Application No: BE/37/21/HH
Site Address: 19 South Way Bersted PO21 5HB
Description of works: Removal of 3 No existing lean-to structures, erection of single storey side & rear extension, loft conversion to form new 2nd floor with roof alterations to form gable end with rear dormer projection & detached outbuilding to be used as annexe to existing dwelling.

Thank you for your internet representation made on 15th April 2021 which has been recorded as an objection with the comments as follows:

sheet 2 of 4

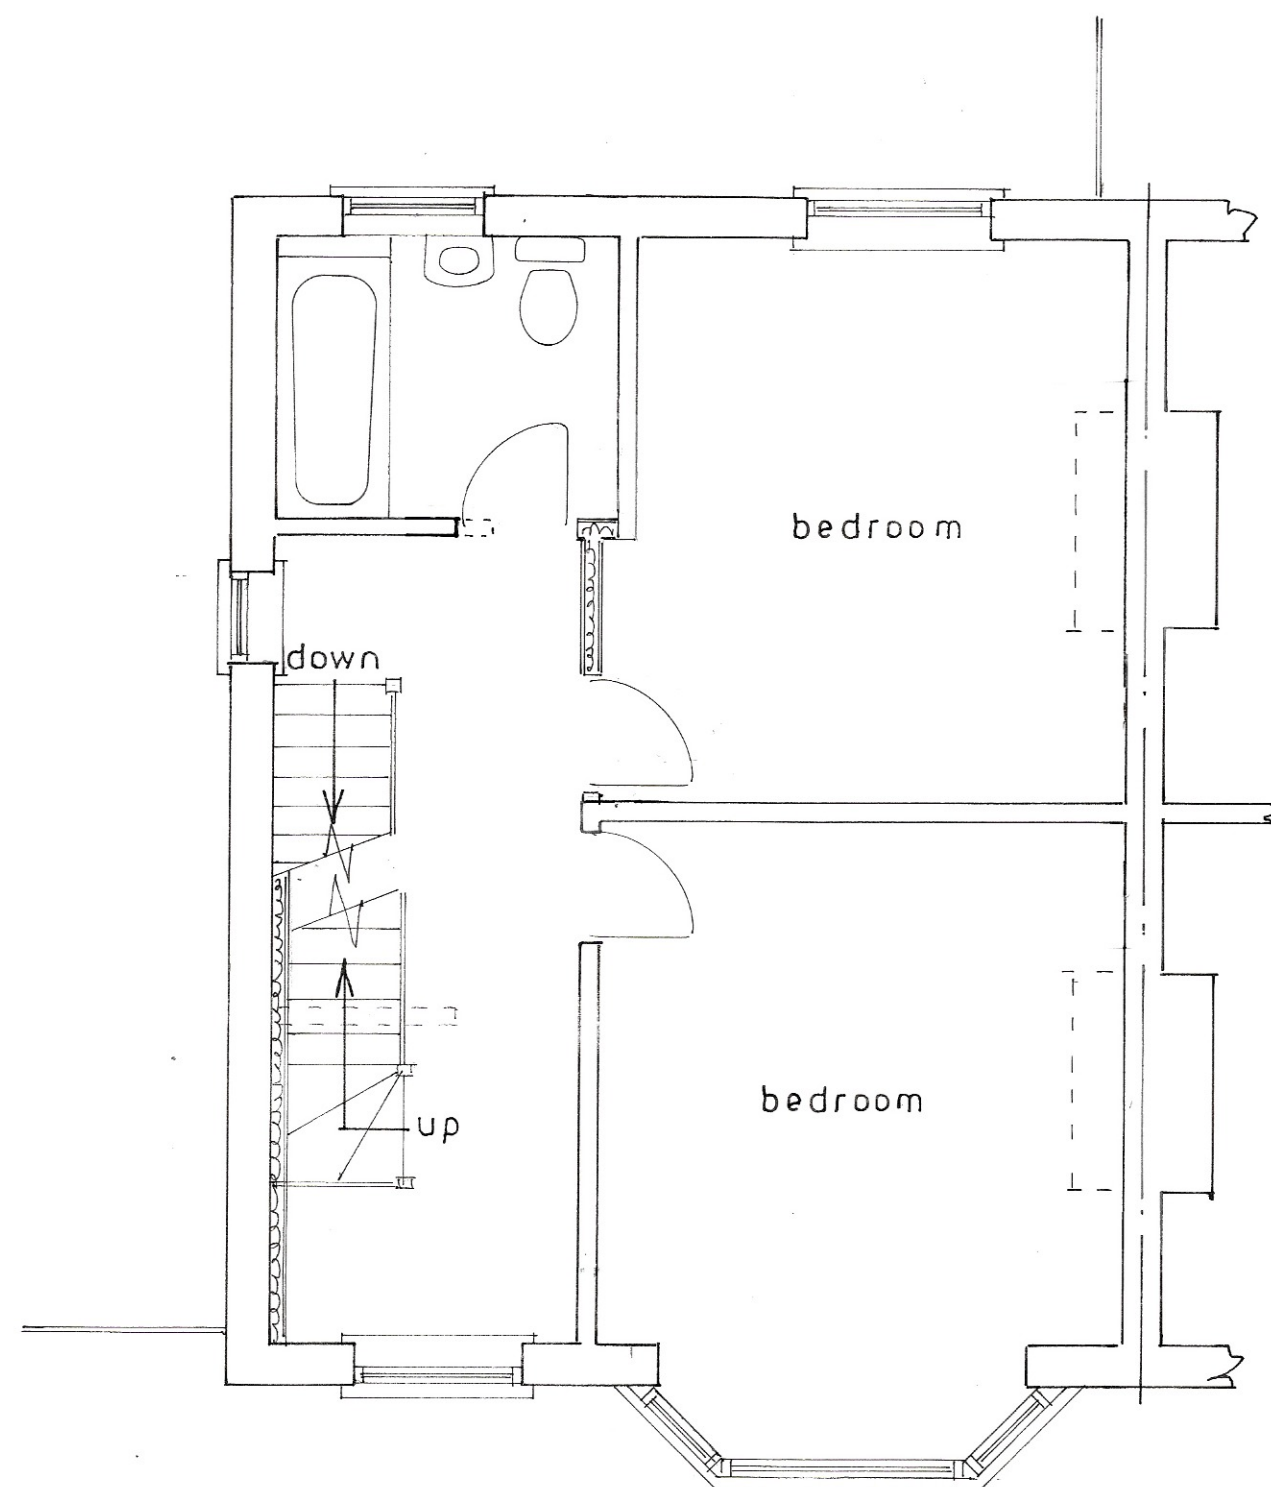
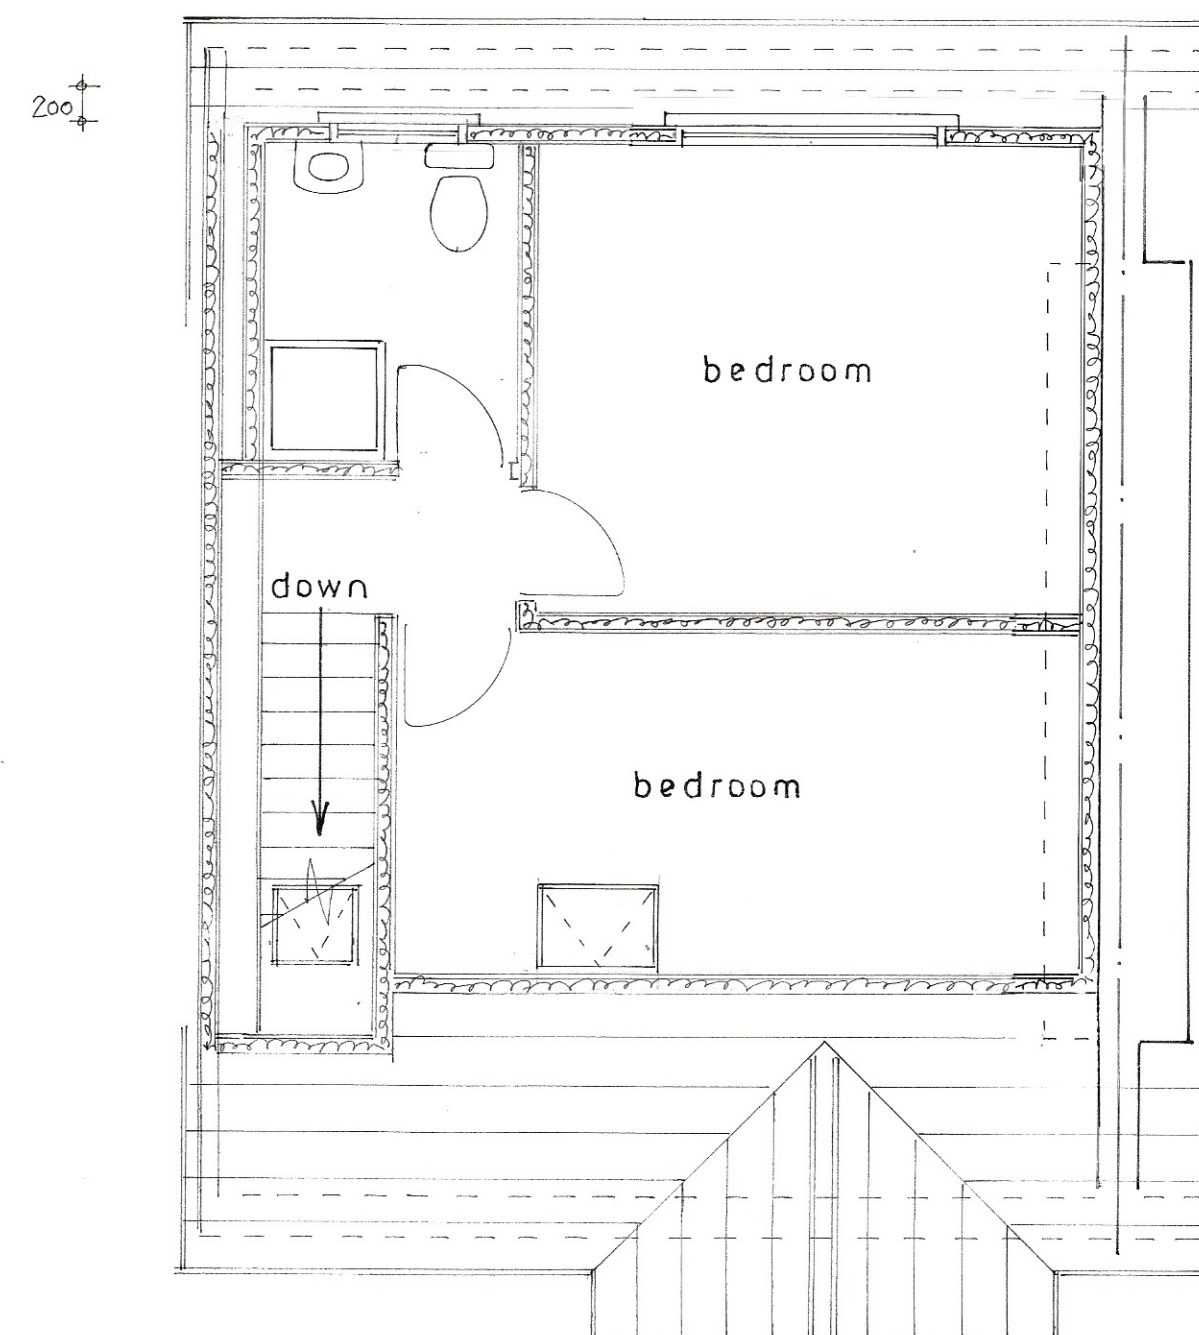
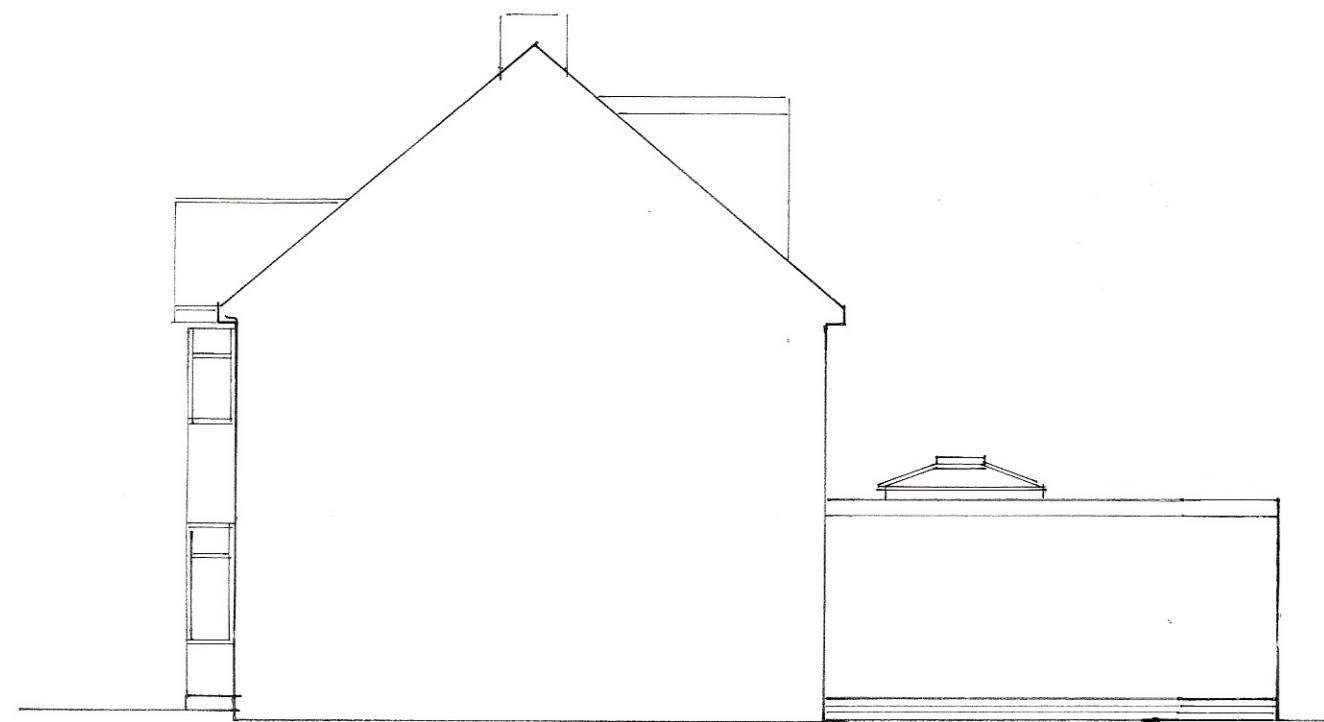
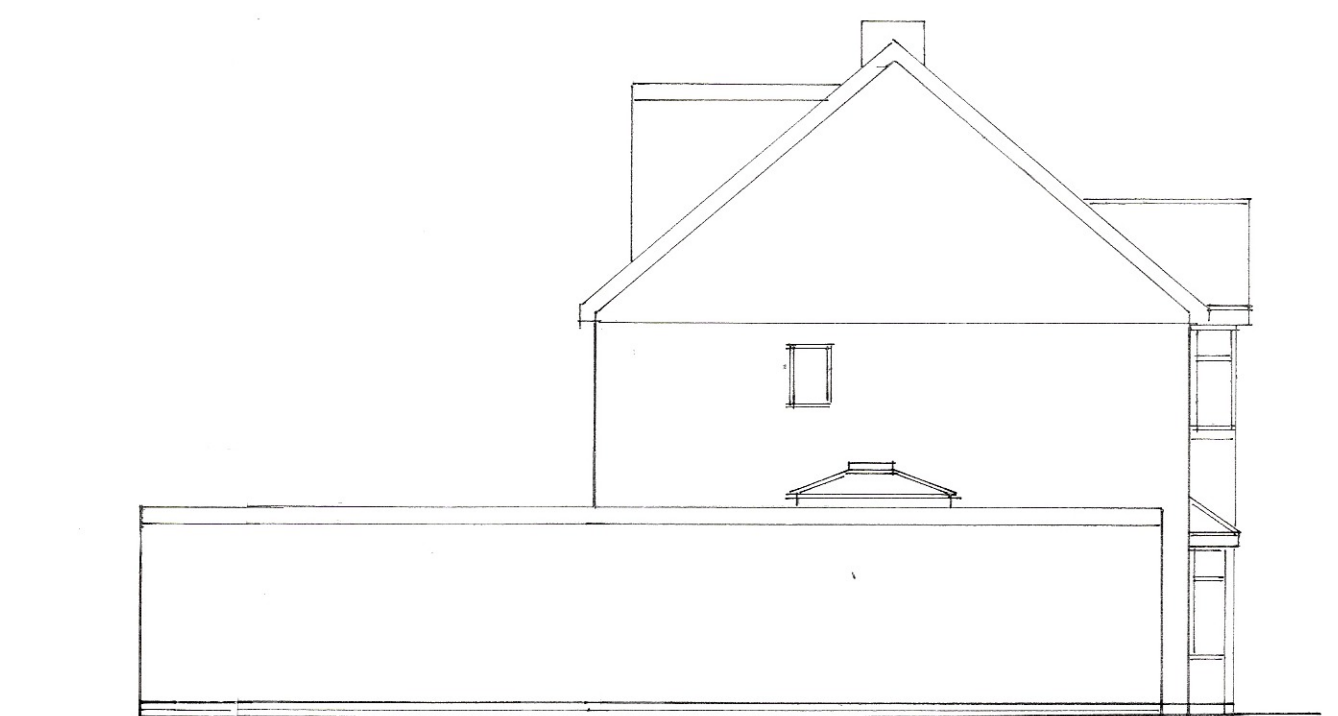
I feel the size of the extension and adding 4 extra bedrooms is very large will cause parking issues. The extension will also block out light in our house.
